NJA Town Planning Ltd
The Beehive
City Place
Gatwick
RH6 0PA

Please ask for: Mrs D Johnson
Email: daun.johnson@arun.gov.uk
Telephone: 01903 737762
Our Ref: CM/64/21/PL
Your Ref:
Date: 10th November 2021

Application for Planning Permission

Development: Use of land for Class B8 (Storage) for caravan storage. This application may affect the setting of listed buildings & is in CIL Zone 3 (Zero Rated) as other development.
Location: Land Adjacent To Church Farm Barn Horsemere Green Lane Clymping BN17 5QZ

Drwg. No.	Rev.
21/239 - 01

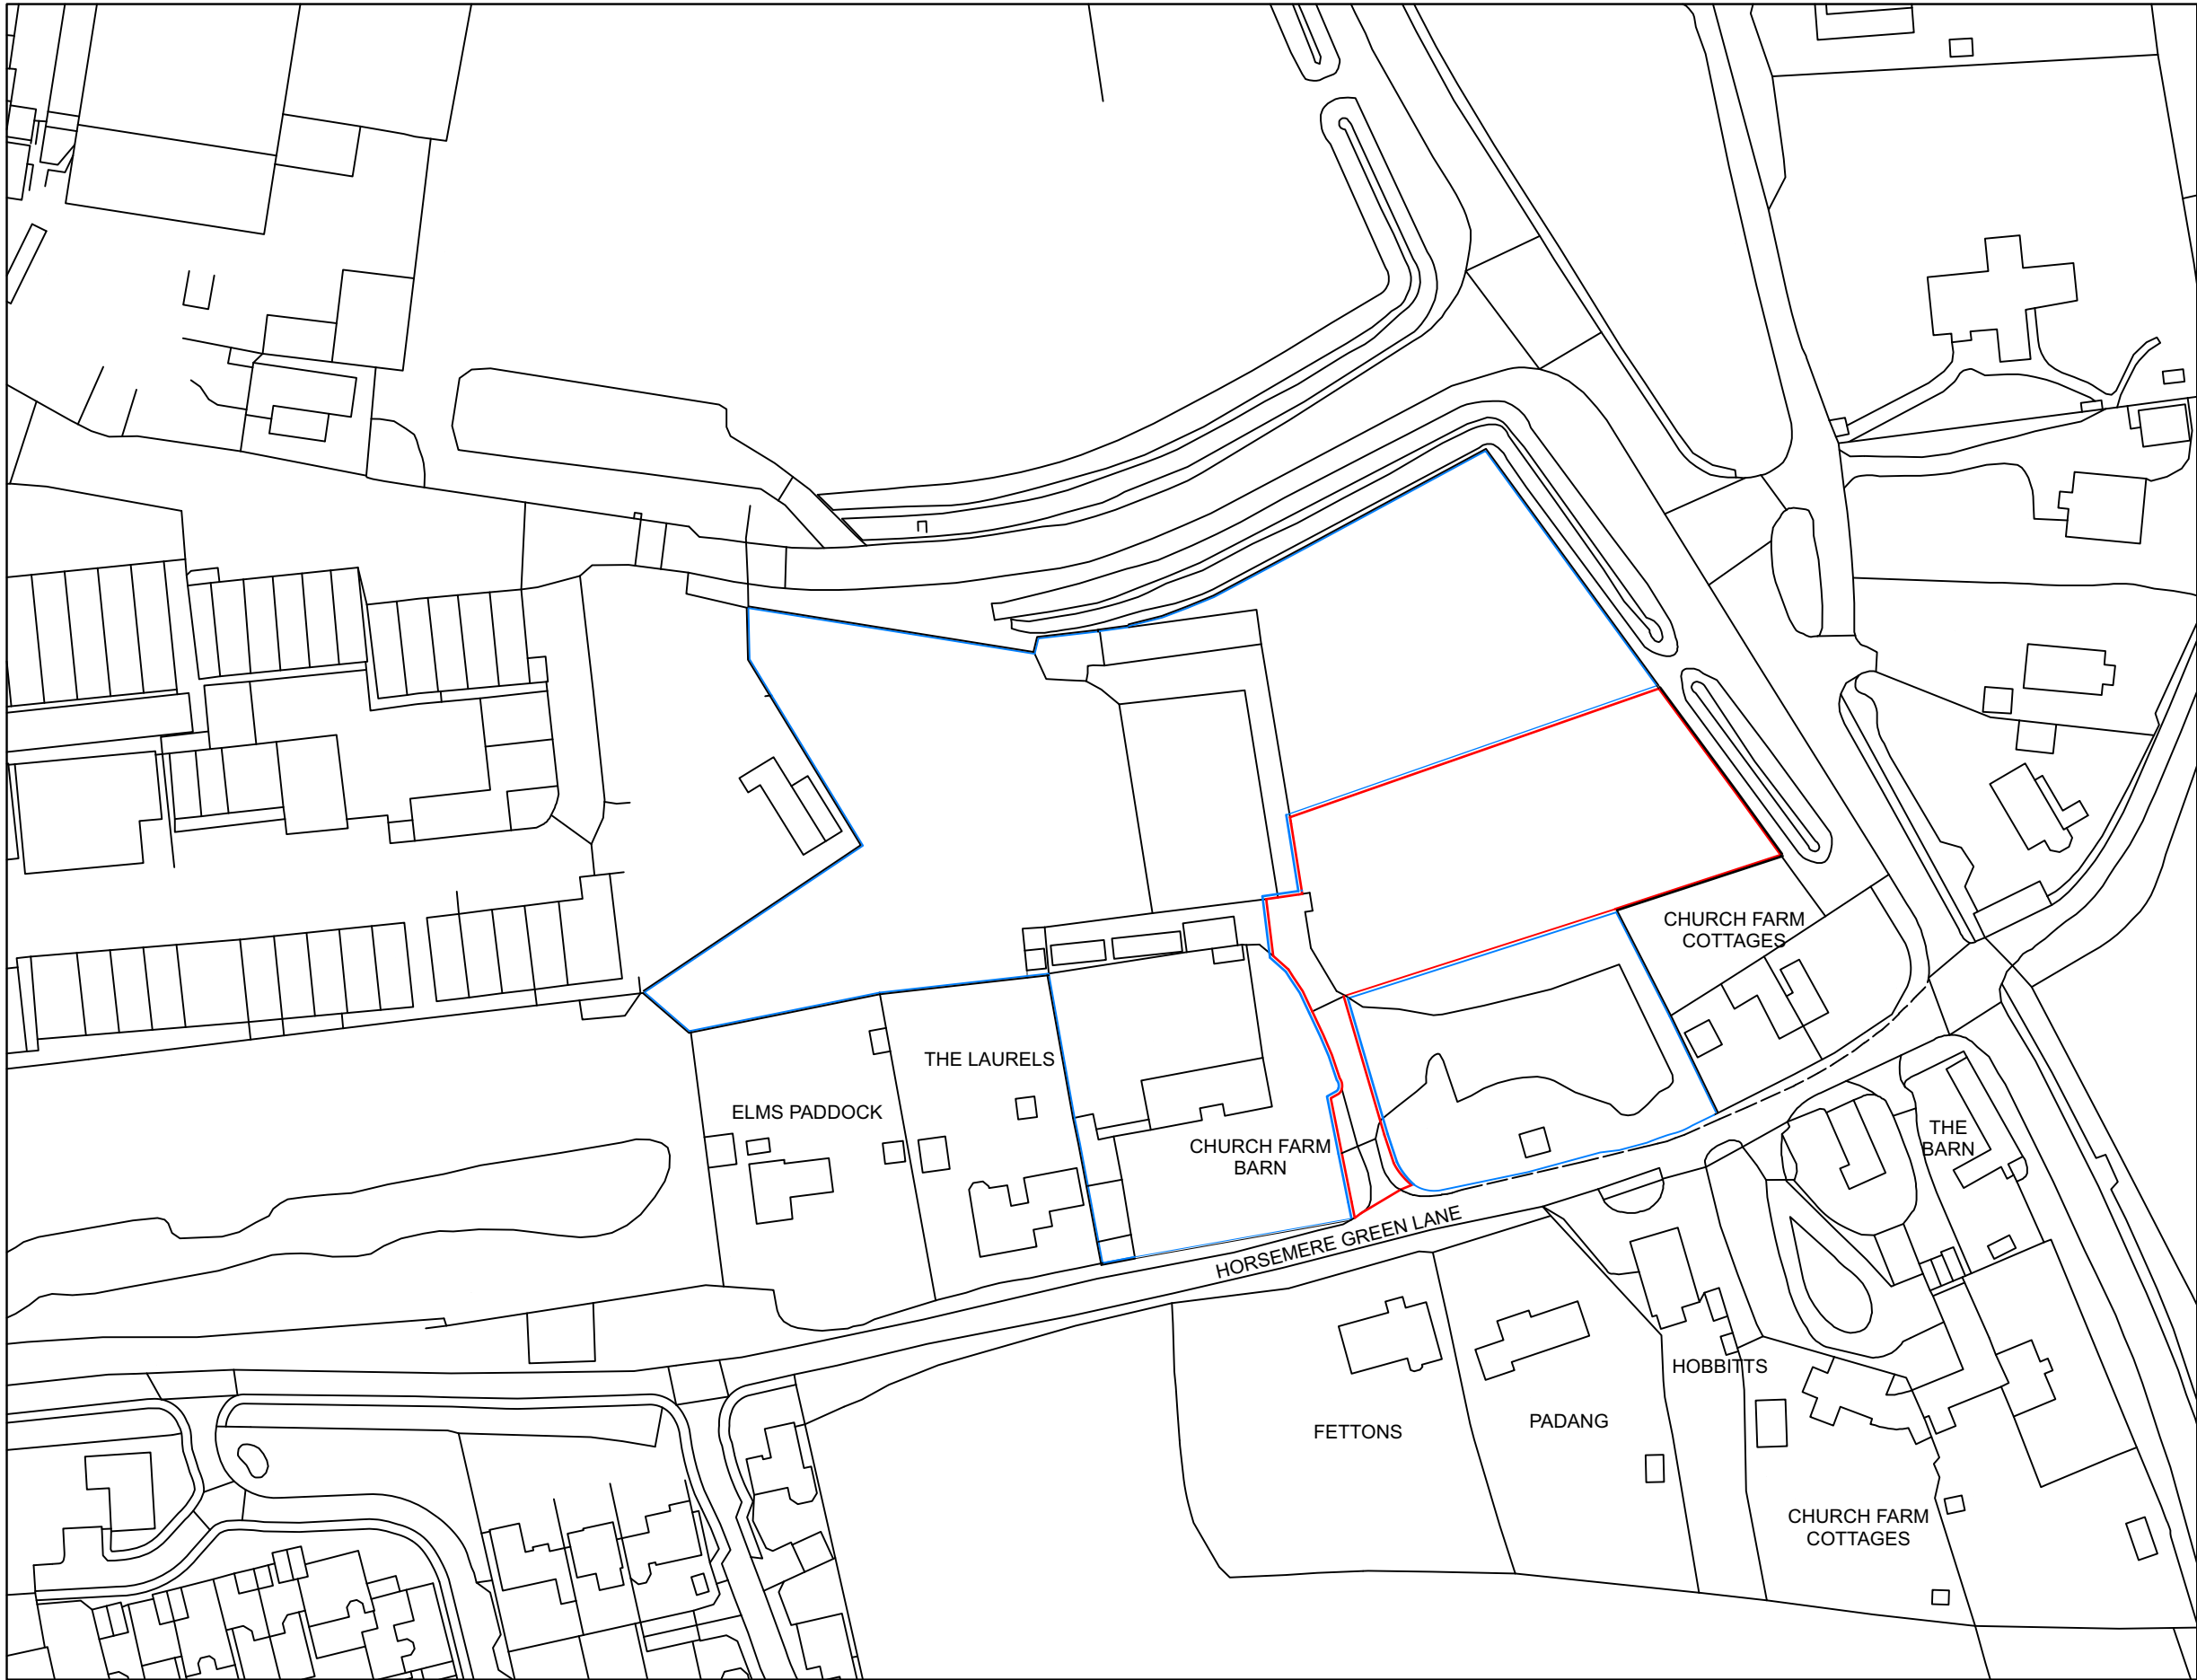
Location Plan

Please provide a full blue edge.
